Gage Farm Barn, Sibford Road, Epwell, Banbury OX15 6LH

TO: George Smith, Planning Officer, Cherwell D C

Planning Application 21/01081/F Matthew Platt, comments due date 18/05/21

Elevation B'

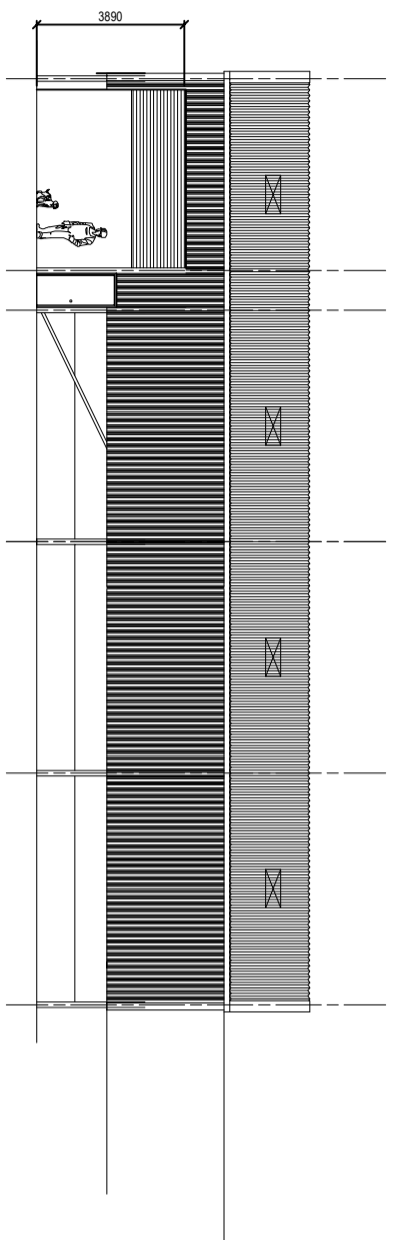
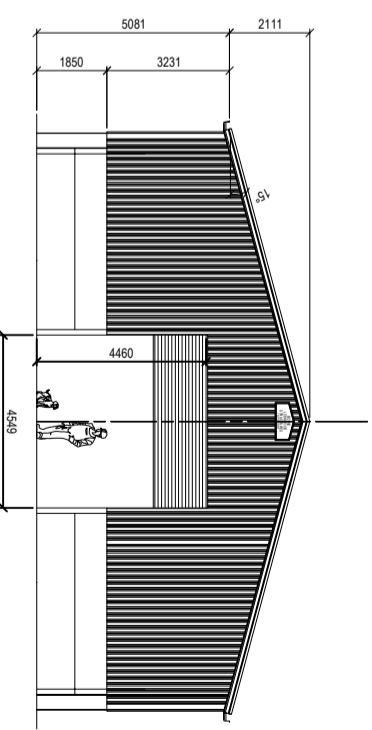
1. Whilst we understand the necessity for a small barn for the protection and security of equipment associated with the scale of the lavender planting the proposed barn is of excessive size [375sqm] both in height and dimensions and would have a seriously detrimental impact on the open field with footpaths running close by and adjacent to the road dropping down to the village of Epwell.

6. Should any planning permission be granted by Cherwell DC, could the building be reduced in size and particularly in height so that it does not have such an impact on the visual beauty and grandeur of the wood and trees, many of which are splendid Scots Pine trees, and a visible landmark from miles around as well from the footpath walks that cross the field, especially on the descent towards the village of Epwell. [Footpaths Sibford Gower 348/16 and 348/17 both cross this field and 348/11 is a Bridleway above the adjoining field.] All these footpaths wholly or in part overlook Spring Field and are frequently used by many Epwellians and by longer distance walkers who value the unspoilt nature of this landscape.
